**Ann Machado - RE: 416 Fore Street - Permit #2015-00535**

**Subject:** 416 Fore Street - Permit #2015-00535

A1.01

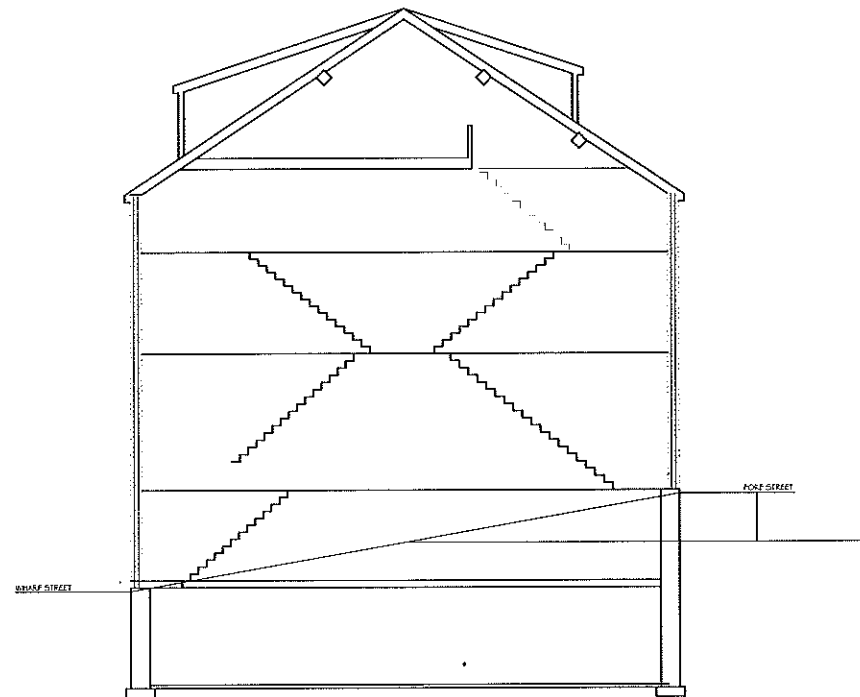
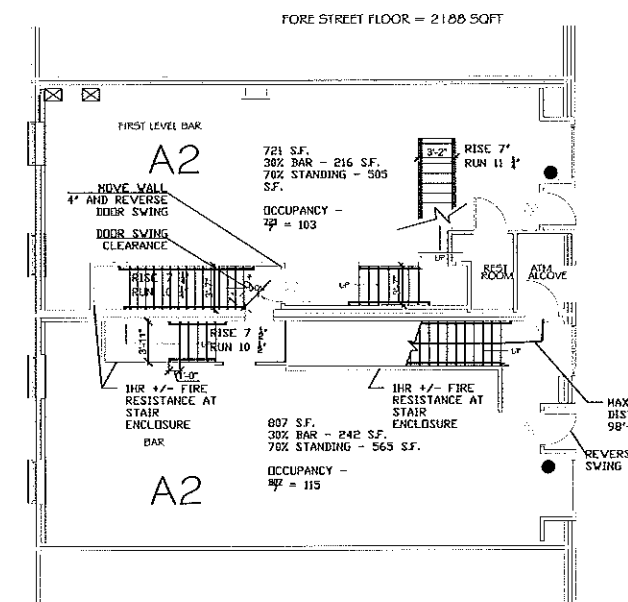
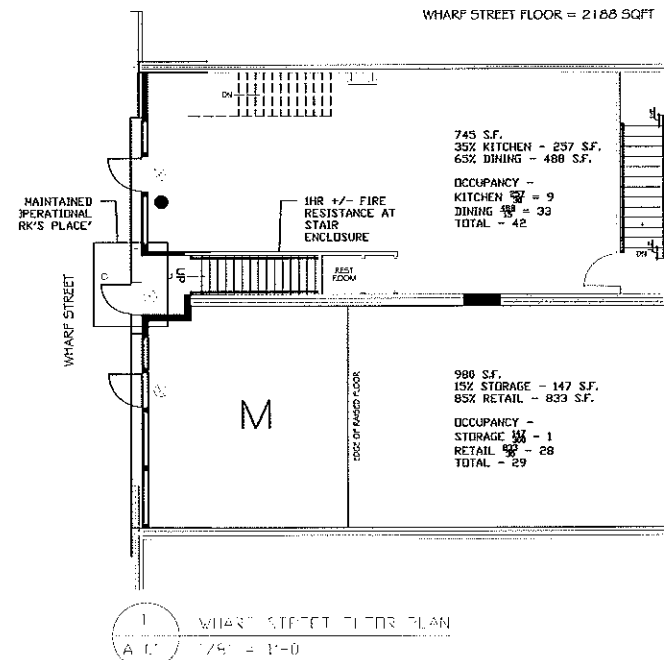
What is Plan A1.01 showing? Is this existing or proposed? Looking at the various floors from this plan:

basement Plan

- there appear to be two storage areas that connect. Which tenant or tenants is the storage area connected to?

Wharf Street level

- you have the use as Bar/ restaurant on the left side of Wharf Street. Is the principal use restaurant or bar? What is the layout of it - Kitchen? bathroom ? seating?

- you have the right side space as mercantile. you break it down as retail, storage and one toilet. Where are these located? Is there a specific tenant for this space?

Fore Street - 1st floor

- you have a bar /restaurant on each side.- is the principal use going to be bar or restaurant? There is a kitchen on one side where Joe's NY Pizza used to be. What is the actual set up for each side - tables, bar, bathroom?

Second floor - Fore Street

-once again what is the layout for the Bar/restaurant? Is this connected to the 1st floor bar/restaurant?

All uses shown are what was in place at the time of the fire except the mercantile on wharf street. It was formerly one restaurant tenant. I would note we are not filing for a permit to occupy the space called at as mercantile with a tenant but would hope to in the near future.

They may be separated in the future as there is no tenant for the spaces at this time

There is no tenant for these spaces at this time

Mark's Place occupies the east side of the 1st floor on Fore St. It is a bar. A plan of the existing layout is attached to our submission.

There is no layout to the for this space at this time
